West Burton Solar Project

The Applicant's Cover Letter

PINS reference: EN010132
Document reference: DEC/WB8.1.50
The Infrastructure Planning (Examination Procedure) Rules 2010

West Burton Solar Project – Submissions to the Secretary of State
Application Ref: EN010132

Figure 8.18.3: Landscape and Ecology Mitigation and Enhancement Measures West Burton 3 Revision A

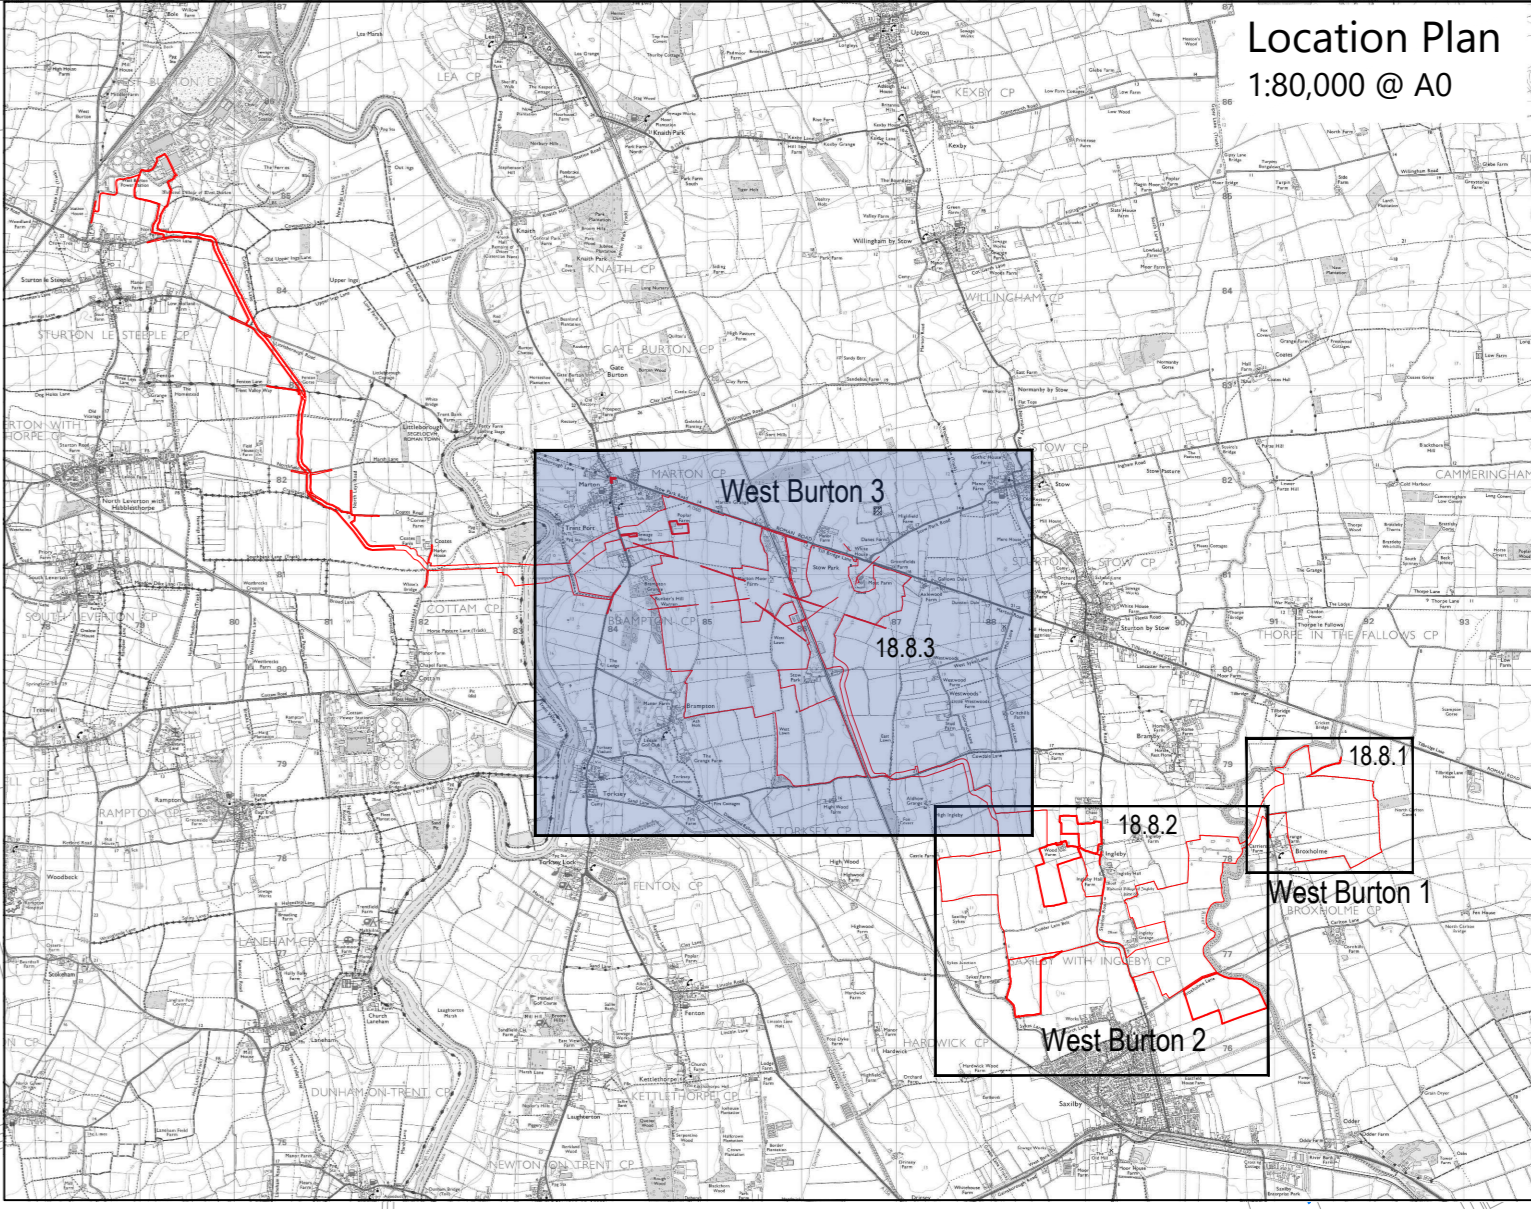
In its submission of 6 December 2024, Lincolnshire County Council (LCC) noted a discrepancy between the Proposed Habitats Plan in Appendix C of the Biodiversity Net Gain Report [DEC/WB6.3.9.12_B] and the plan Landscape and Ecology Mitigation and Enhancement Measures West Burton 3 [DEC/WB6.4.8.18.3_B] submitted on 17 October 2024.

The Applicant has reviewed the comments of Lincolnshire County Council and agrees that part of field P5 on the eastern edge of the Deer Park is showing in the BNG Report figures as land for solar arrays, battery storage and substations. This labelling is intended to distinguish areas of above-ground development from below-ground cable routing, with the latter not being included within the BNG calculation. The area within field P5 referred to could potentially be used for landscaping and, accordingly, was included in the revised calculations for Biodiversity Net Gain (BNG) presented in the Biodiversity Net Gain Report [DEC/WB6.3.9.12_B].

The Works Plan [DEC/WB2.3_F] provides the definitive extent of the works permitted in each area. Article 3(2) of the draft DCO [DEC/WB3.1_I] requires each numbered work to be situated within the corresponding numbered area as shown on the works plan. Sheet 6 of the Works Plan confirms that Work No. 6C, which includes landscaping and biodiversity mitigation and enhancement measures, and the electrical and communication cables (Work No. 1C(iv)) are the only works that may be located within this area of field P5.

The Applicant has, in response to LCC's concerns, reviewed the submitted BNG calculations. If the small area of land within the Deer Park and field P5, identified by LCC, was removed from the calculations (i.e. excluded from the baseline, and with no new biodiversity measures or landscaping placed in this area), the BNG percentages would all increase in comparison to those contained within the report submitted in November 2024 [DEC/WB6.3.9.12_B]. The net gain for habitat units increases from 100.82% to 104.28%; the net gain for hedgerow units increases from 51.1% to 51.41%; the net gain for river units increases from 38.01% to 41.48%.

The Applicant hopes that this is sufficient to clarify any confusion over the calculation of BNG within the BNG Report. The Applicant does not consider that it is necessary to update the BNG Report as those figures are indicative only, demonstrating that the minimum BNG units secured by Requirement 9 of the DCO can be provided by the Scheme. The final number of BNG units to be provided by the Scheme will be confirmed in the BNG Strategy submitted to the relevant planning authority for approval pursuant to Requirement 9.
